**INDEPENDENT EXPERT
ADVISORY PANEL FOR MINING**

**HUNTER VALLEY OPERATIONS
CONTINUATION PROJECT
(SSD-11826681 and 11826621)**

July 2024

Advice No: IEAPM 202407-2

Figure 10 - Hunter River Paleochannel

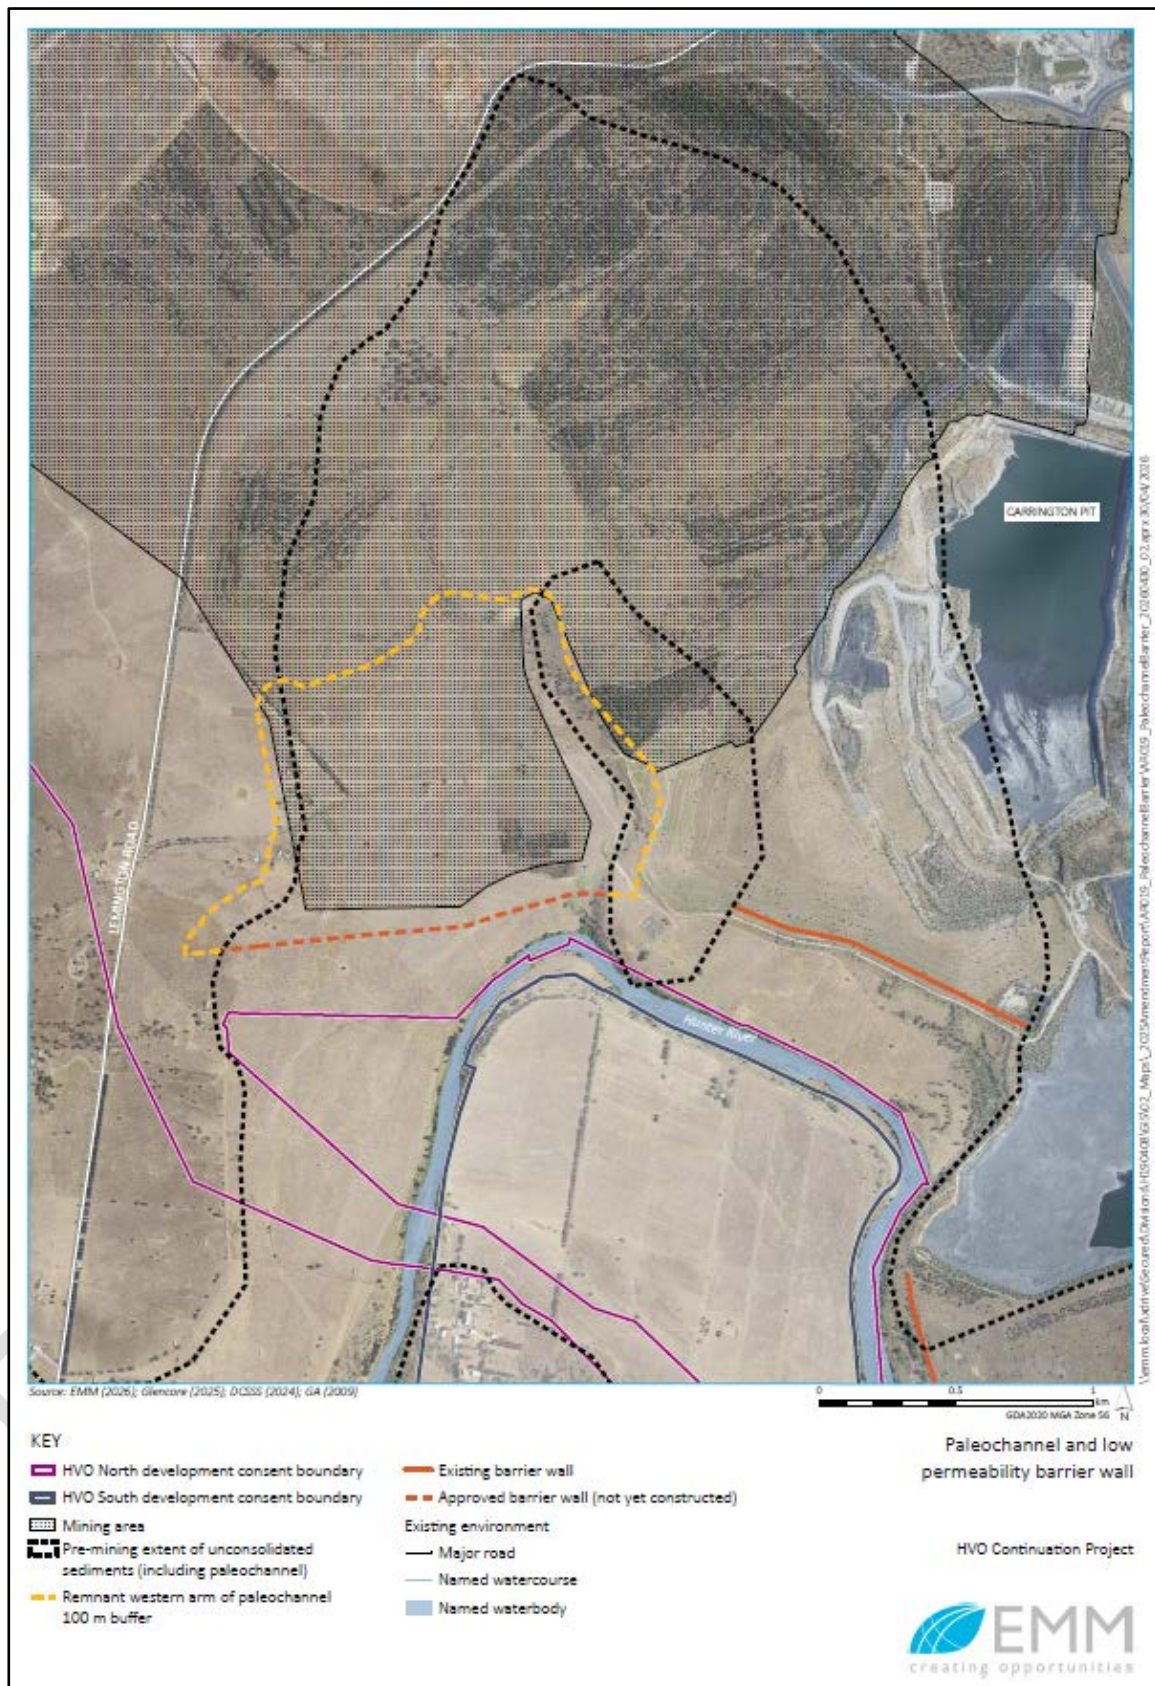
9. *Carrington West Wing barrier wall installation* prior to mining encroaching the paleo-alluvial channel is expected to be beneficial for mitigating drawdown in the Hunter River alluvium. Appropriate risk assessment and related modelling is required to support development of the planned Trigger Action Response Plan (TARP) for the wall and the associated monitoring design.

- c. A TARP for the Carrington West Wing barrier wall and associated groundwater monitoring. To develop the TARP, groundwater modelling should be undertaken in support of a risk assessment, first, to assess what constitutes an unacceptable barrier wall failure in

terms of groundwater impacts and, second, to assess options for groundwater monitoring to identify such a wall failure. Non-invasive methods of monitoring such as surface electrical resistivity surveys should be investigated as an alternative to, or an adjunct to, groundwater monitoring using nested piezometers. If HVOPL does not proceed with these methods, sufficient justification must be provided.
